**RE: Juan Tabo Hills Estates Preliminary Plat, Project # 1005278**

The purpose of this letter is to explain how the comments as contained in the DRB Official Notice of Decision (May 21, 2015) have been addressed. The following items have been revised and are being re-submitted for review and approval.

1. Preliminary Plat (including Sheet 1 Vacation Exhibit),
2. Infrastructure List,
3. Sidewalk Exhibit
4. Perimeter Wall Detail
5. Grading and Drainage Plan

NEW SANITARY SEWER EASEMENTS

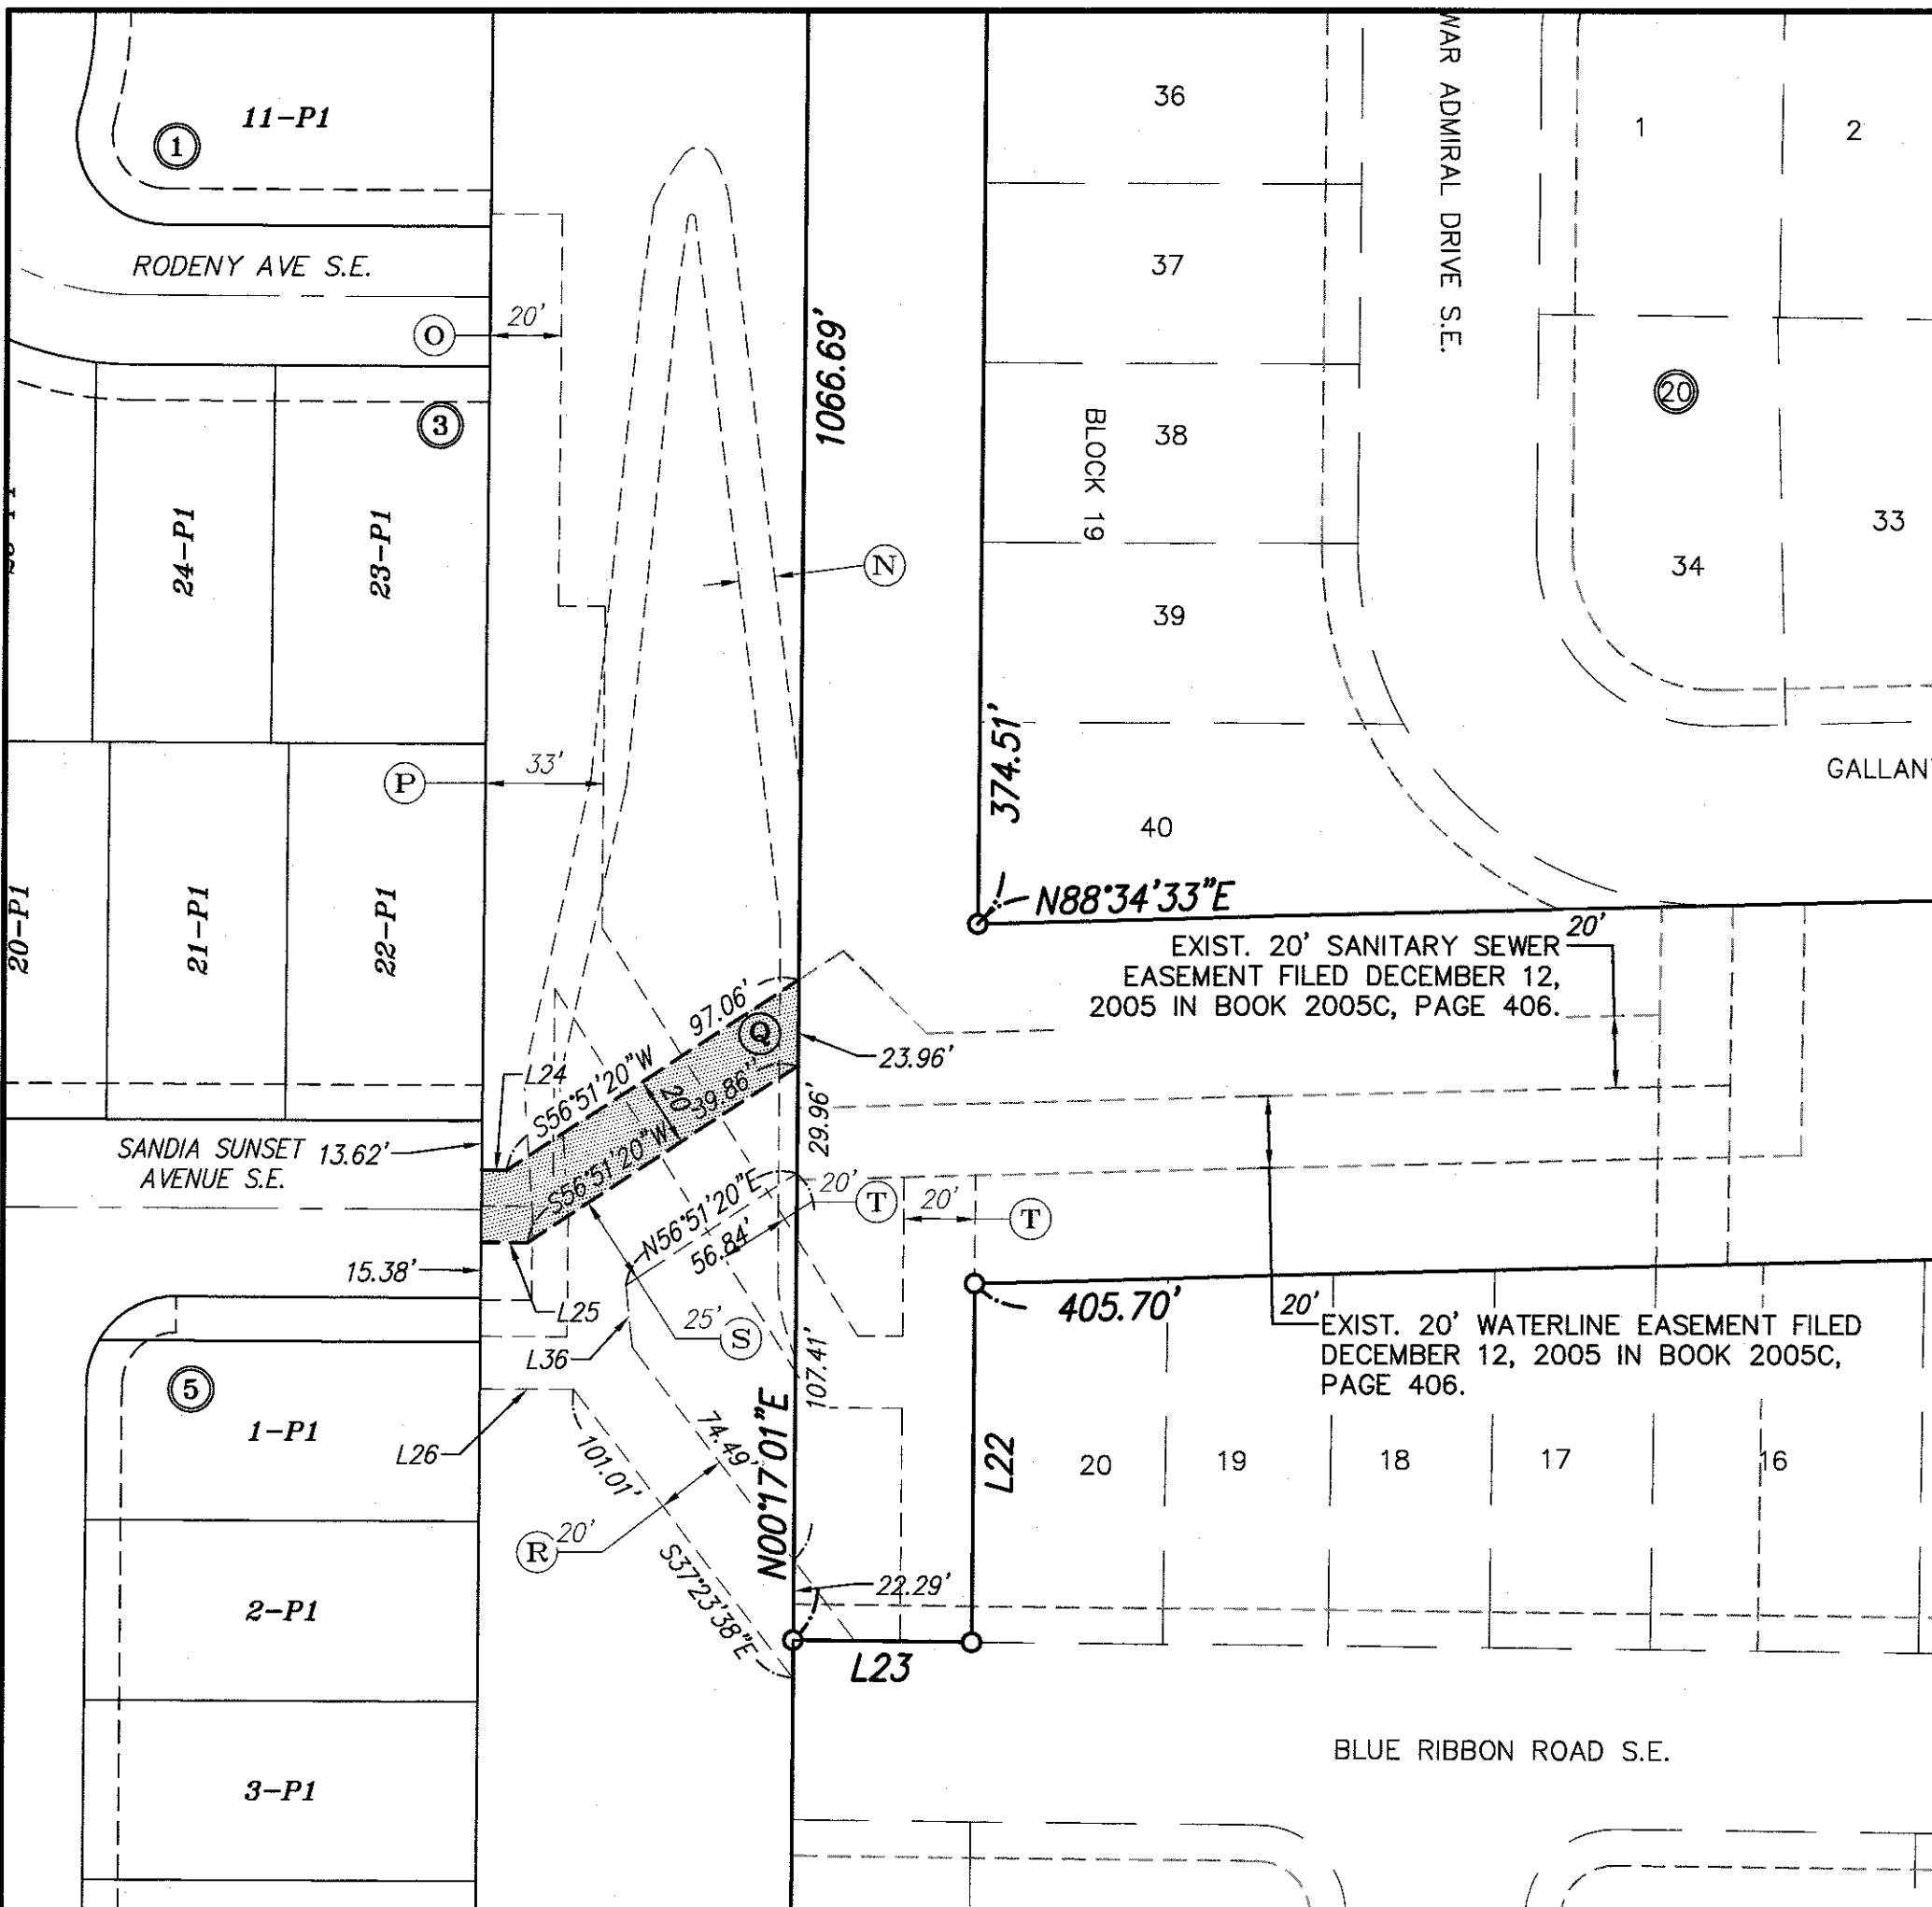
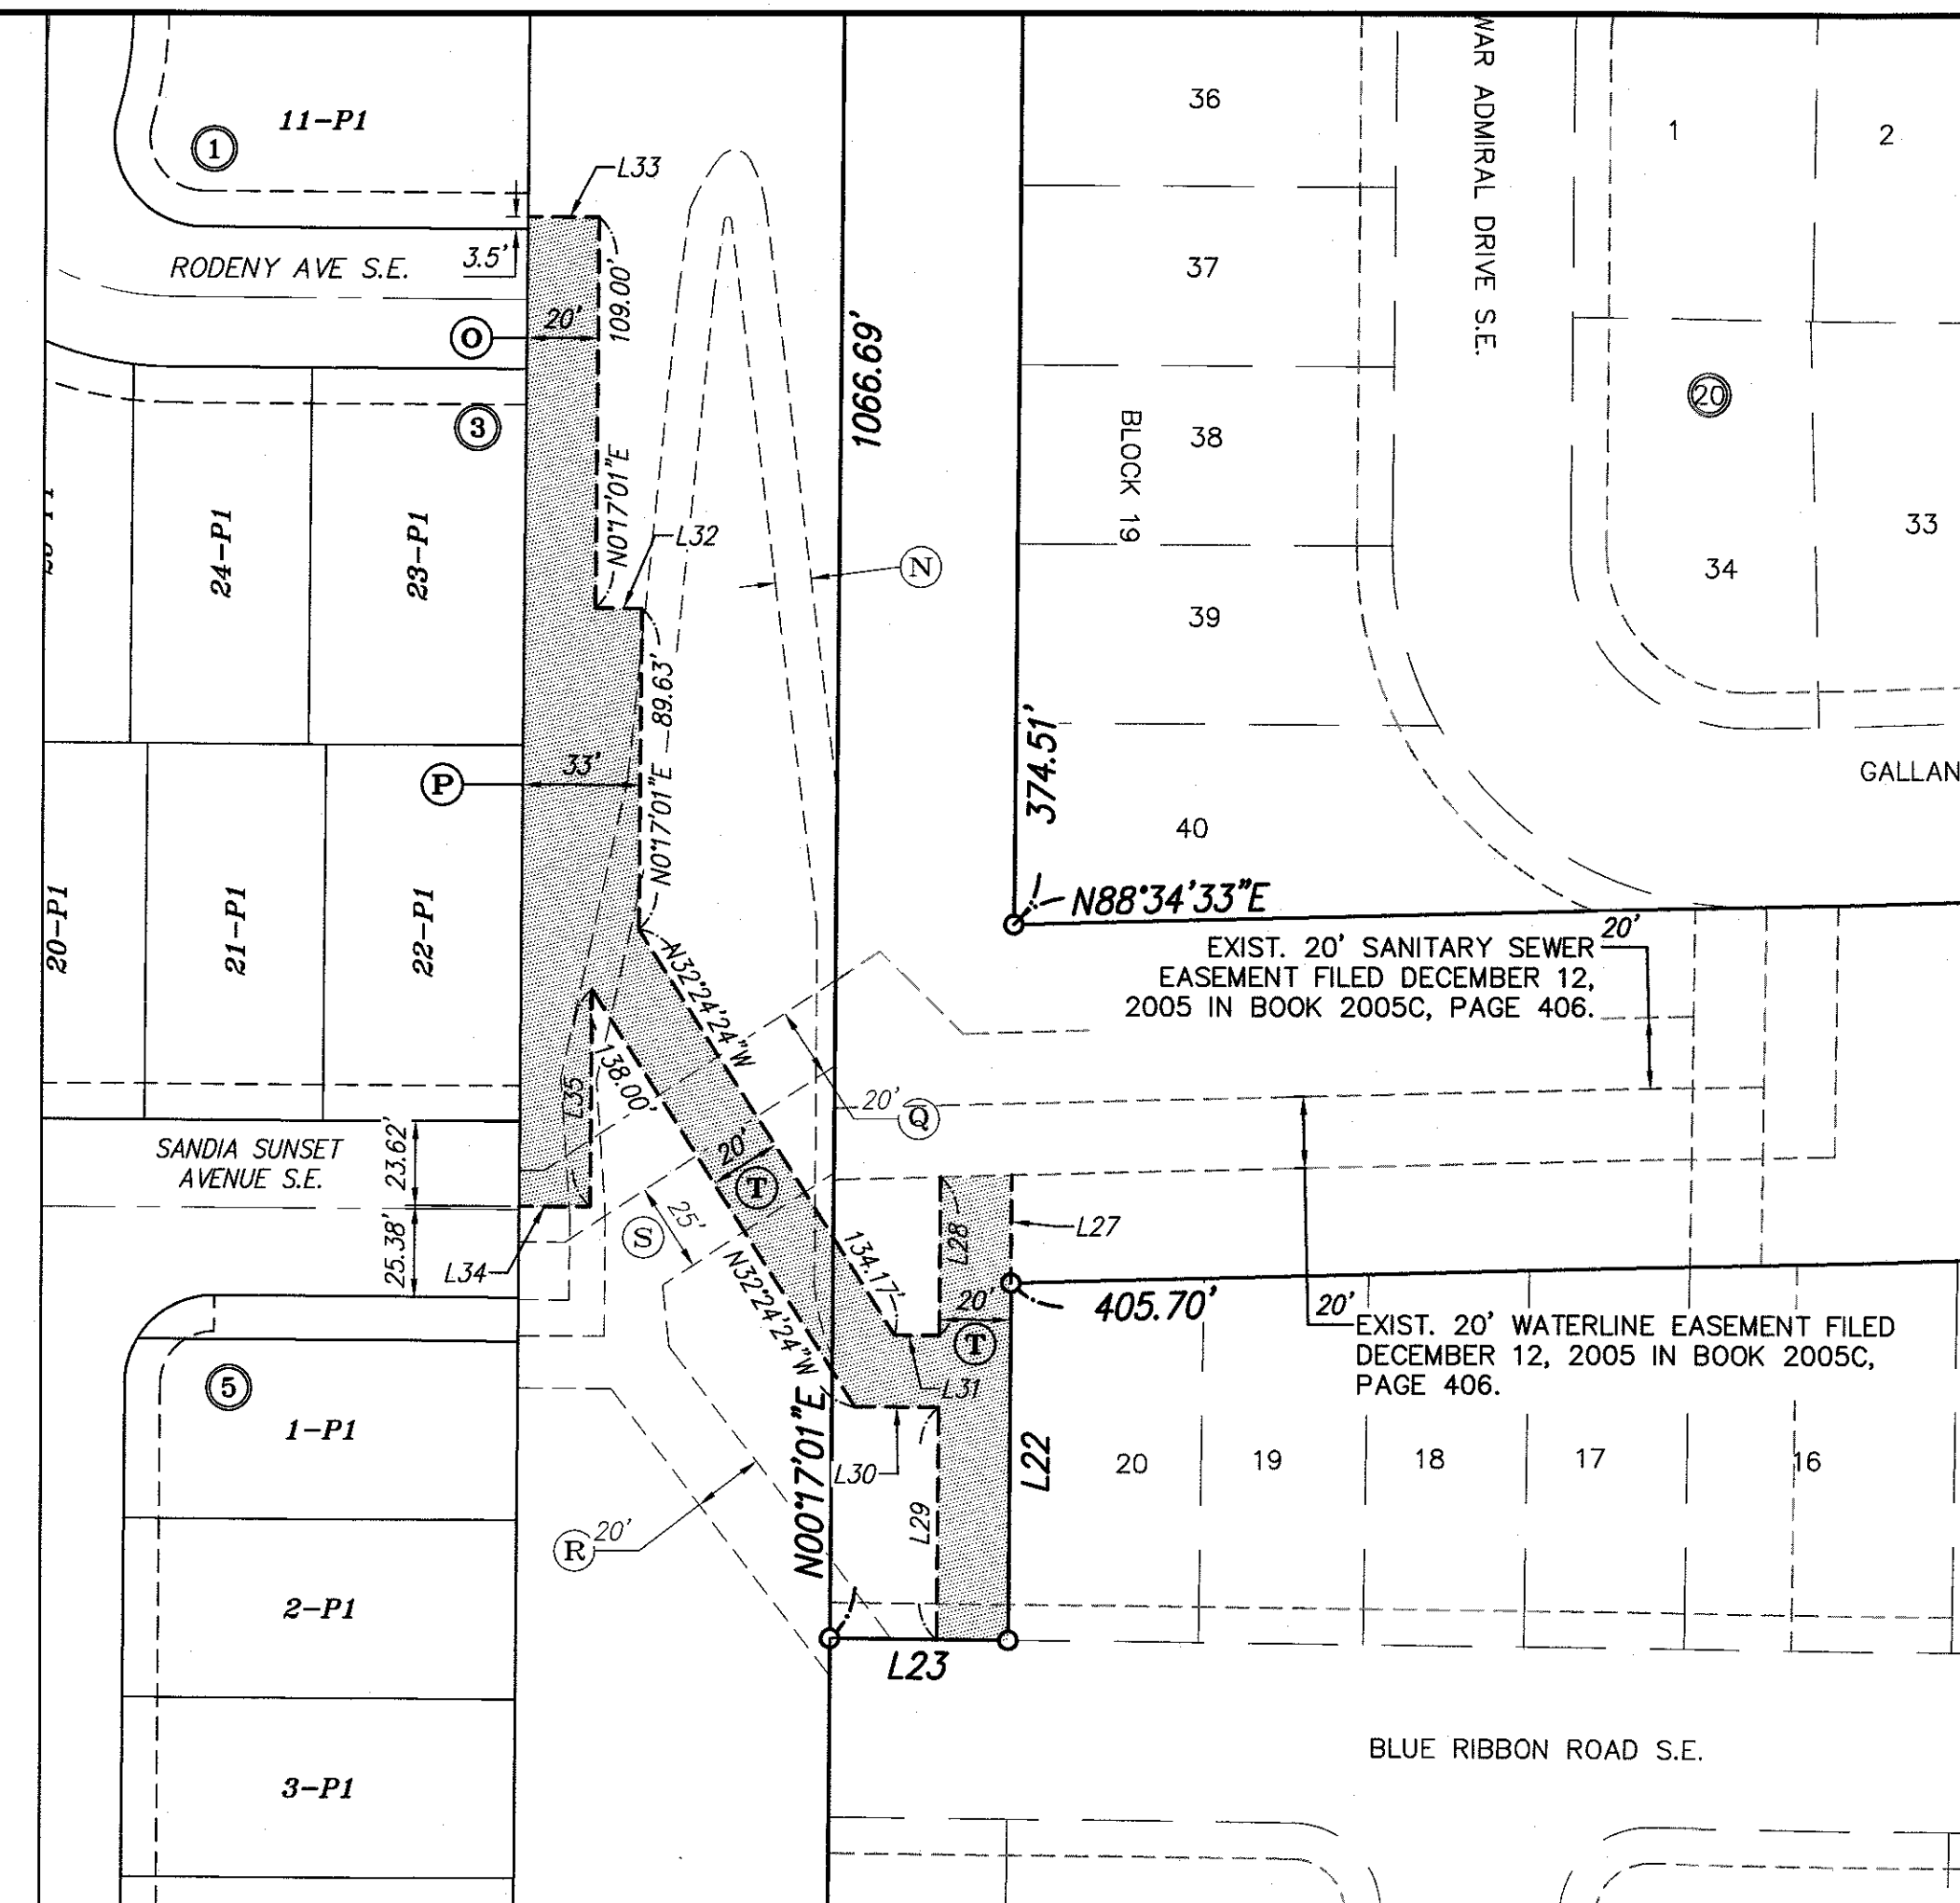
ABCWUA comments (1.) A development agreement has been submitted to ABCWUA for Board approval. It should be introduced to the Board at the October 21 meeting and then hopefully approved at the following meeting on November 18. (2.) Mark Goodwin is not willing to provide an acknowledgement letter. (3.) Site Plan comments are not applicable since the Conceptual Utility sheet has been removed from the Site Plan. However the Conceptual Utility Plan has been updated and provided as an aid to review of the Preliminary Plat and the Infrastructure List. (4.) The Infrastructure List has been revised by (4.i) changing the 8" water lines to 10" in Pocono Rd, Silver Dollar St, Manzano Vista Ave, Rock Squirrel and Sandia Sunset, (4.ii) 8" water line connection added between the existing line in Blue Ribbon Rd and the existing line in Tract 1-A-1-B which connects to Gallant Fox Rd., (4.iii) the 6" waterline in the stub on the south end of Hubbard remained 6" on the infrastructure list and was changed to 6" on the Conceptual Utility Plan, (4.iv) the north end of the Canyon Wren water line was changed to 8", (4.v) the 6" water lines in stub streets were changed to 4" water lines, (4.vi) the White Dove St. water line was changed from 6" to 8", (4.vii) the removal of the existing 21" SAS was added, (4.viii) the removal of the existing 8" SAS in Tract 1-A-1-B was added, and two Pressure Reducing Stations were added to the Infrastructure List. (5.) The Preliminary Plat was revised by adding the Vacation of a portion of Tract D to Sheet 1, and by separating the storm easements from the sanitary and waterline easements.
